re: Geotechnical Response to City Comments
 Proposed Residential Development
 Kanata Lakes Golf Club - 7000 Campeau Drive - Ottawa
to: Minto Communities - Ms. Beth Henderson - bhenderson@minto.com
date: May 17, 2021
file: PG4135-MEMO.03

Geotechnical Comments

ad drawings\geotechnical\pg41xx\pg4135\pg4135-permissible grade raise p

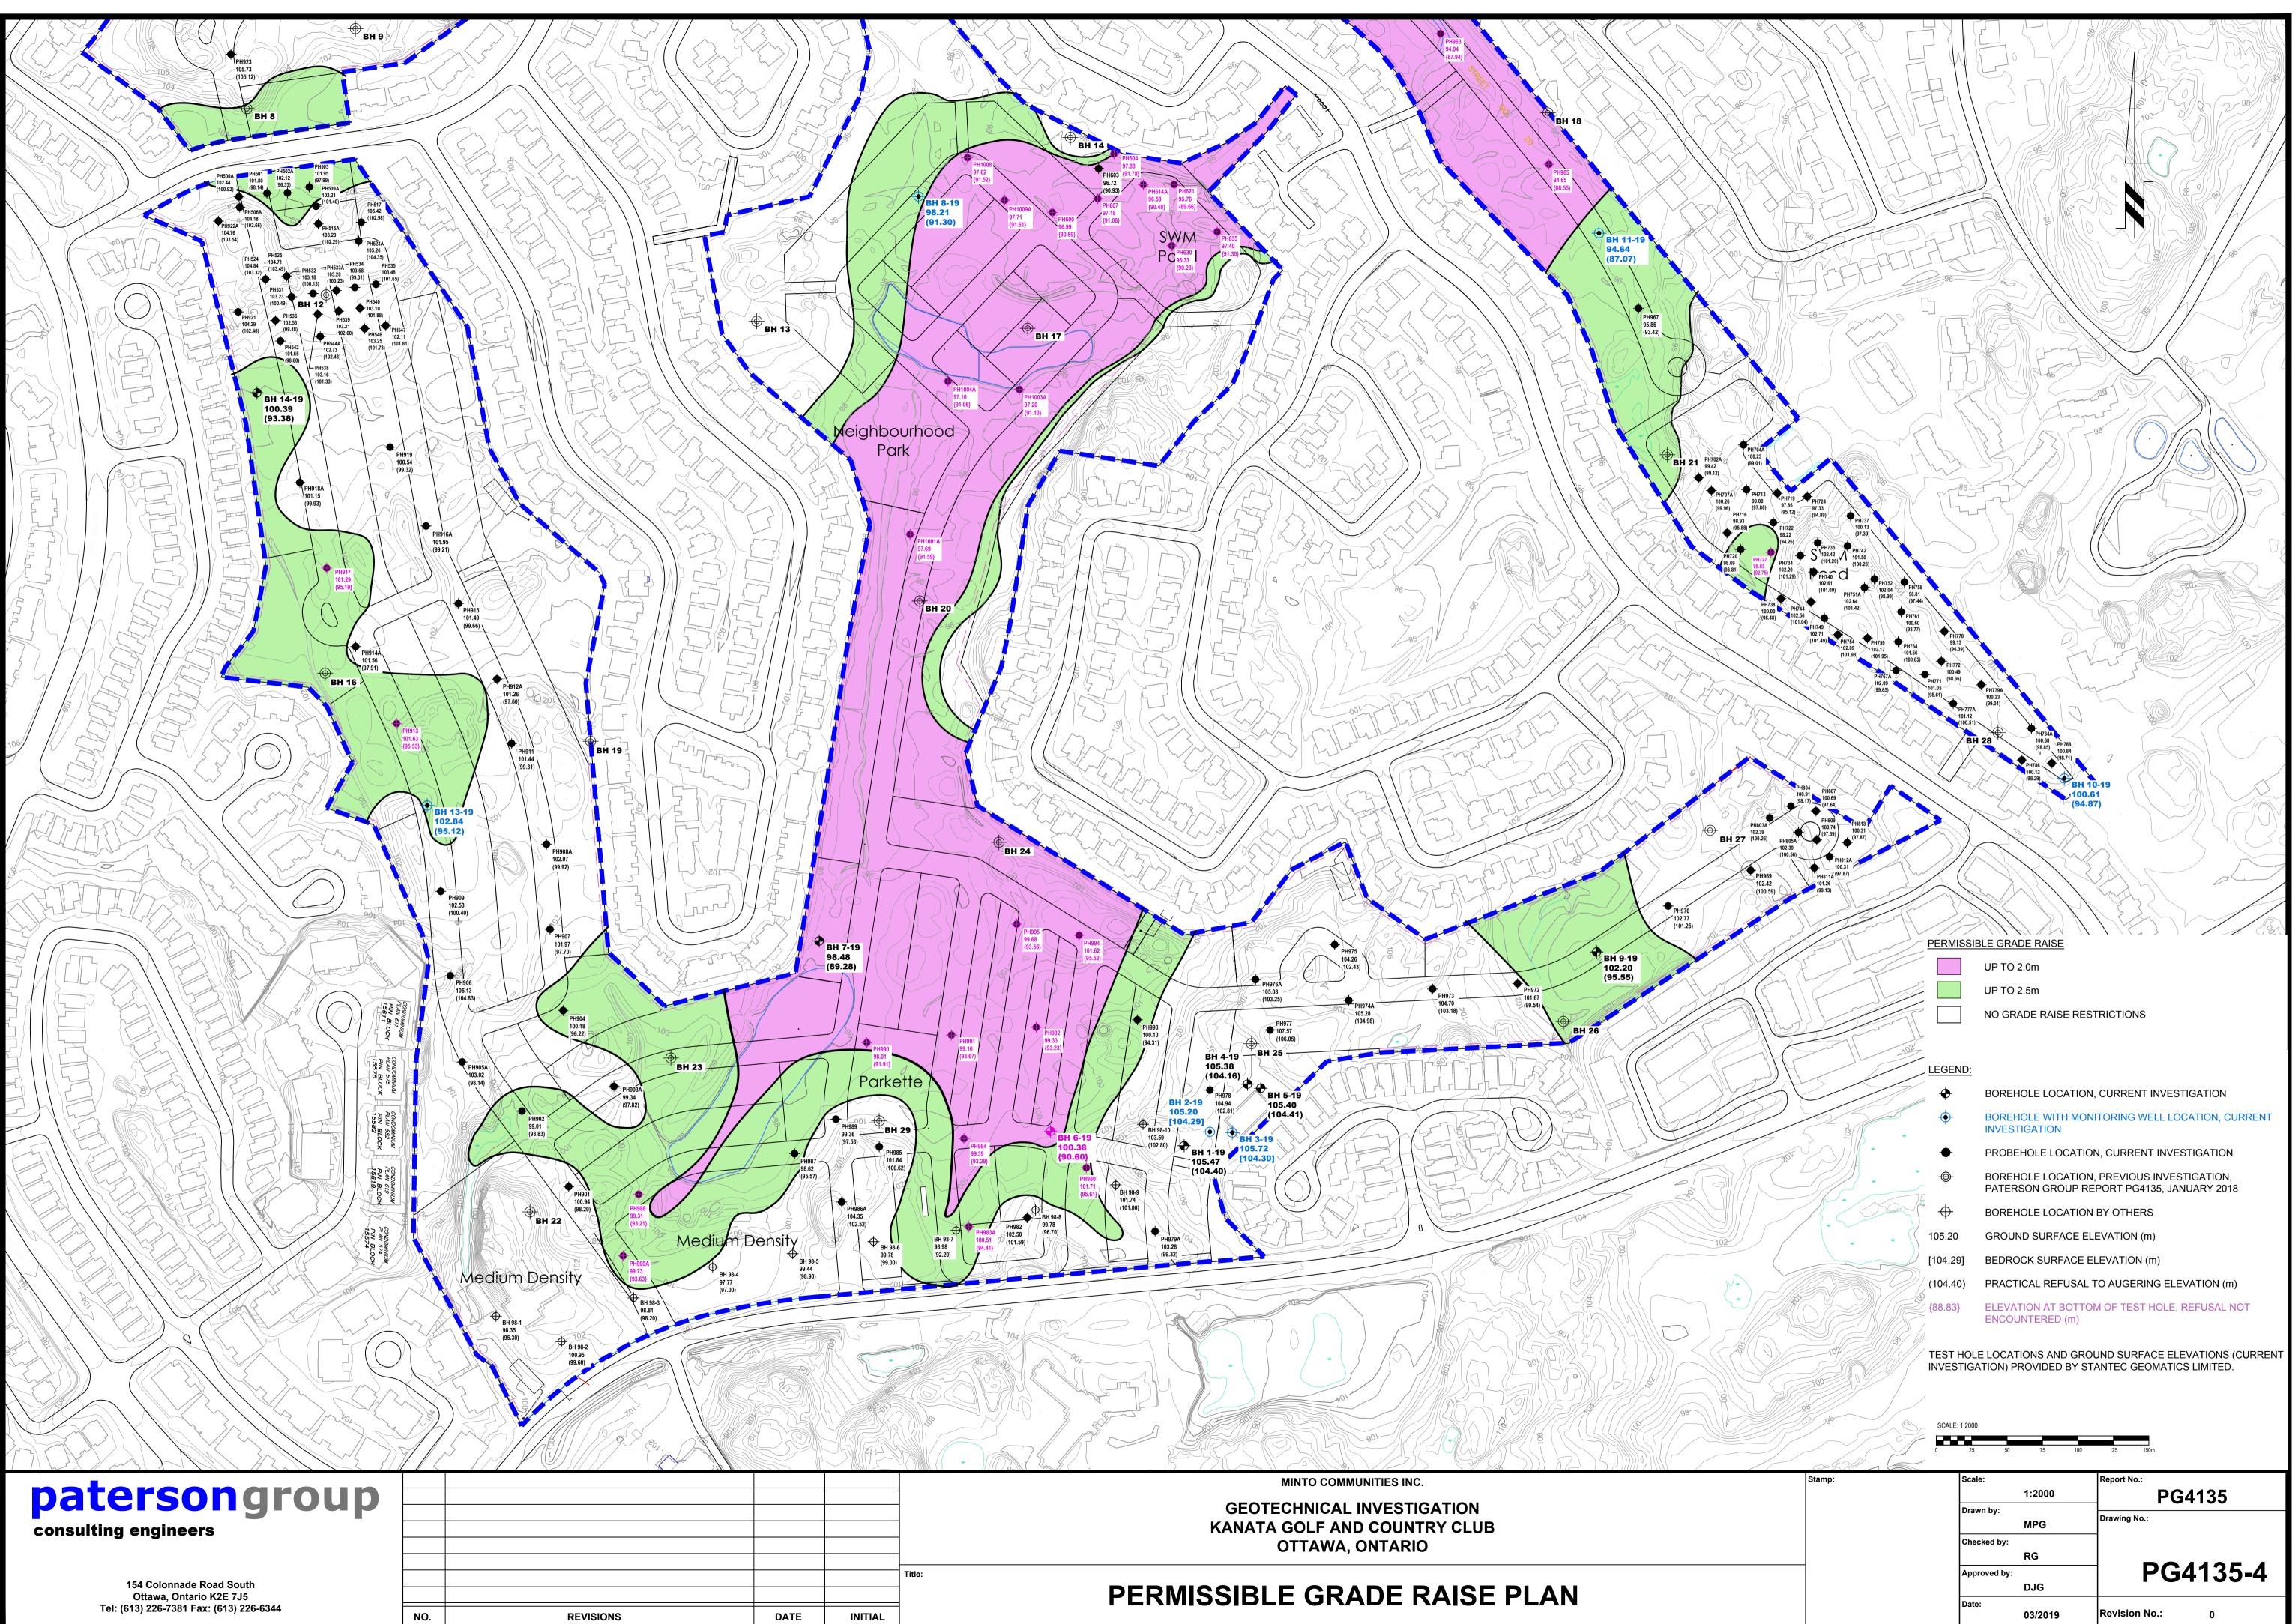
Comment No. 51 : *Tree planting setbacks are not provided in Appendix 2, drawings PG4135-3 and PG4135-4 as indicated. Please address original comment 114. (Followup comment 114: Any future development Blocks located within the subdivision (i.e. to be developed by site plan later) are to be modelled with a realistic runoff coefficient value reflective of the proposed zoning).*

Response: As described under Section 6.8 of our revised report, the tree planting setbacks corresponds to the same areas where permissible grade restrictions are to be applied. Area 1 covers the area where no grade restriction is required. Area 2 covers the area where a grade restriction is to be applied. Nevertheless, this has been highlighted in the legends of the Permissible Grade Raise Plans PG4135-3 and PG4135-4 enclosed in Appendix 2 of the revised geotechnical report PG4135-2 Revision 5 dated May 17, 2021. It should be noted that in areas where the design finished grades is provided with a minimum vertical separation of 3.5m from the top of the silty clay, no tree planting setbacks will be required. This will be defined by the geotechnical consultant by a lot by lot basis upon review of the site grading plan.
